RE: SSD 15_7317 – Australian Technology Park - Response to Submissions

SSD 15_7317 – Australian Technology Park – City of Sydney comments on Response to Submissions Report

Figure 3. Extent of Building 1 height non-compliance shown in unshaded building envelope relative to maximum height limit and adjoining child care centre
Source: Proponent's SSD Application

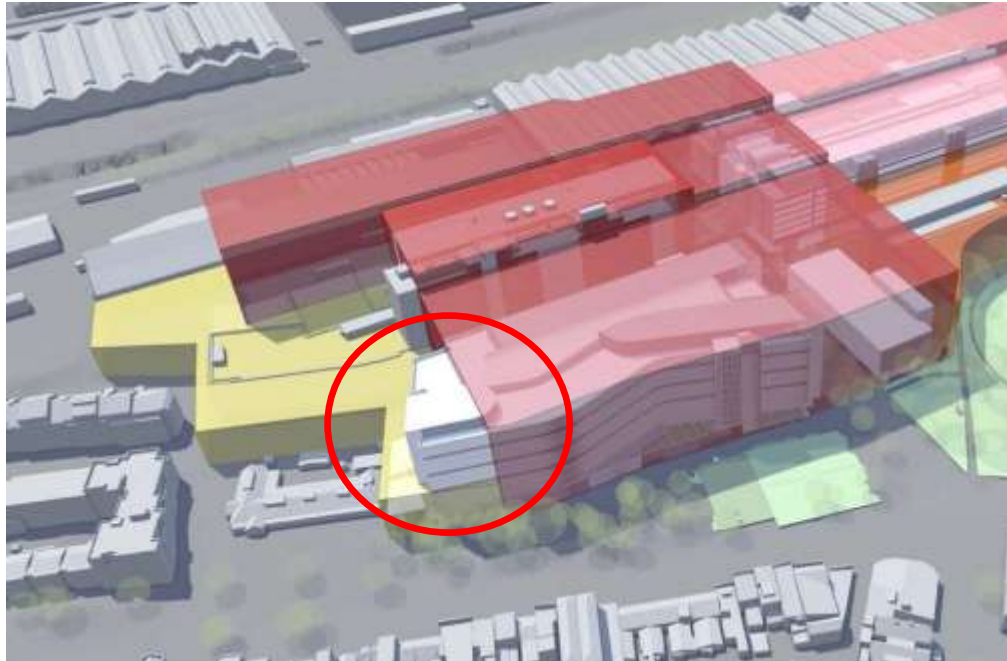
It is patently obvious that non-complying height (spurred on by greater GFA than the planning controls anticipate) is manifestly unreasonable and unnecessary at the western end of Building 1 through excessive bulk and scale, overbearing visual impact from the south and west, stark lack of building height transition from east to west, lack of integration with existing development to the north, excessive overshadowing of properties protected from this impact through the existing controls and excessive visual impact

Issued raised in City submission	Applicant response	Issue addressed?	City's contention
Bulk, Scale and Design			
<p>Building 1 must comply with the building height standard in the Major Development SEPP. The existing 4-storey height control should be enforced and Building 1 height reduced from 9 to 4 storeys by redistribution</p> <p>The SEPP 1 objection lodged is not well founded and cannot be supported.</p> <p>The at-grade car park to the west of Building 1 eliminates any ability to screen and soften the development with landscaping including mature trees.</p>	<p>The RtS concludes that the visual impacts and overshadowing impacts do not unreasonably affect neighbouring properties.</p> <p>The RtS compares a “compliant” scheme with a 4 storey height and minimal western setback to the west with the proposal development.</p> <p>Redistribution of GFA from Building 1 to Building 2 is undesirable due to scale shift in Building 2 adjacent to Locomotive Workshop and associated heritage impacts.</p>	No	<p>The SEPP non-compliance is significant in quantity and quality and should not be supported due to avoidable adverse environmental impacts.</p> <p>A Clause 4.6 objection is not the appropriate planning pathway to propose a significant non-compliance with a key development standard.</p> <p>Media City / the Channel 7 building to the north is appropriately transitioned in height and the proposal, if approved, will be viewed as an anomaly of the planning system failing to uphold the established controls.</p> <p>The non-complying height (propped up by greater GFA than the planning controls anticipate) is unnecessary and unreasonable at the western end of Building 1 through excessive bulk and scale, overbearing visual impact from the south and west, stark lack of building height transition from east to west, lack of integration with existing development to the north, excessive overshadowing of properties protected from this impact through the controls and excessive visual impact, sense of enclosure and loss of sky views on the adjoining child care centre.</p>

(b) require compliance with the statutory height standards.

Figure 6. External car parking results in poor interface with child care centre
Source: Proponent's SSD Application

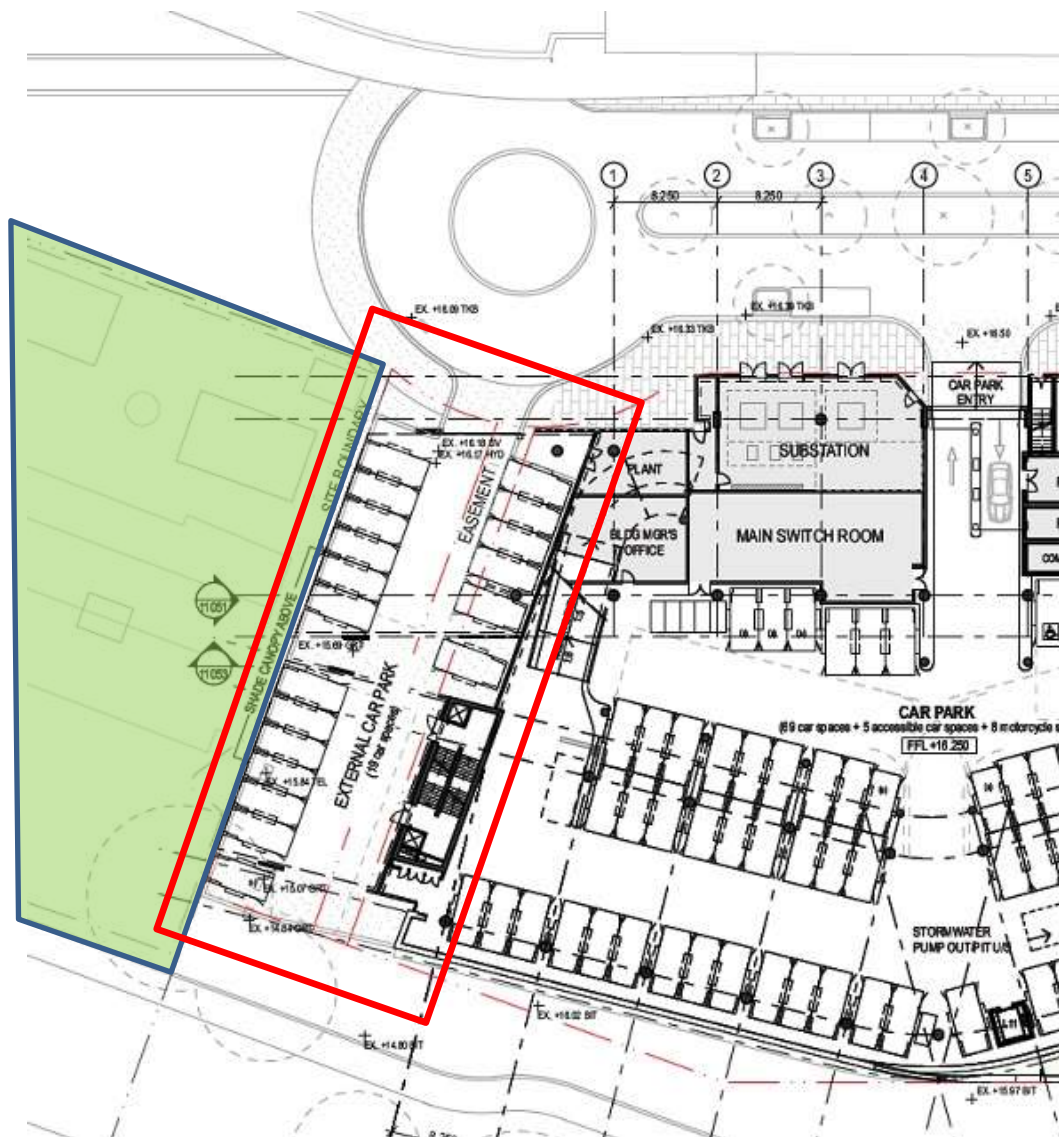
<p>Underground car parking must be utilised across the buildings. All opportunities for undergrounding car parking must be exhausted. The area south of Building 1 requires particular attention.</p>	<p>Various environmental, cost and program implications have been found to severely impact on the option for basement parking. On this basis, Mirvac are proceeding with aboveground car parking.</p>	<p>No</p>	<p>The RtS shows there are no actual constraints to building partial or full basements under Building 1 or Building 2. The construction programme is the key driver. A 6-7 month extension on the programme to build underground car parking, with such structures lasting for anywhere between 15 and about 60 years, is not a sufficient basis to offset the adverse long term building height impacts, visual impacts, poor activation impacts and acoustic impacts of aboveground car parking.</p>
<p>Incorporate a landscaped setback to the west of Building 1 toward the existing child care centre by deletion of the external car park and shade structure and introduction of mass planting.</p>	<p>The car park shade structure has been rationalised. However, at grade parking has been retained to serve the needs of “the CBA precinct”.</p>	<p>No</p>	<p>If the building height is propped up to 9 storeys where a 4 storey height standard applies, then at grade car parking excludes opportunities to screen and soften the development from the west, including the Alexandria Child Care Centre.</p>

Figure 7. Extract of Building 1 floor plan showing design of child care centre outdoor space
Source: Proponent's SSD Application

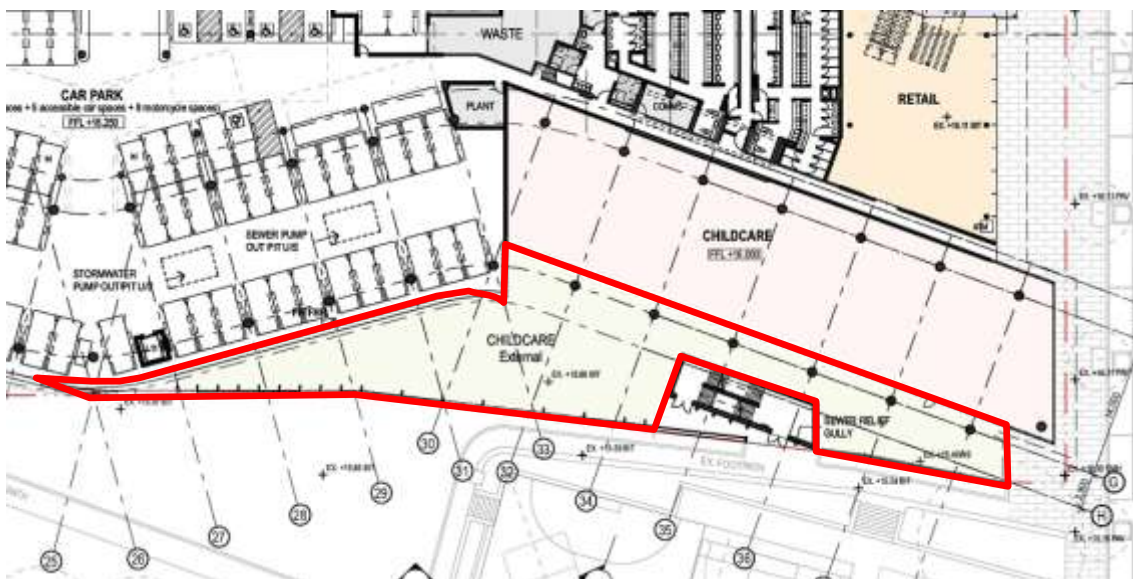
The external spaces of the child care facility in Building 1 requires redesign to address useability, access to sunlight, air quality and surveillance.	The external space is considered acceptable in terms of shape, location and functionality. A solid facade has been introduced between the ground level car park and the child care play space.	No	The shape and orientation of the play space lacks sunlight, useable area (through fire stairs cutting the most useable portion) and clear sight lines for carer surveillance due to narrow angles and structural obstruction.
Redesign the south-eastern corner of the Community Building to wrap gym or retail active frontage toward the Vice Chancellor's Oval and proposed play space.	The area of the retail space has been expanded to the south to increase activity and the alfresco dining area will better integrate the building with the public domain.	Partially	A minor improvement exists when extending the retail space and associated outdoor dining area closer to the Oval. However, the gym was already proposed in that space. The activation of the proposed play area remains very poor and requires reconsideration.
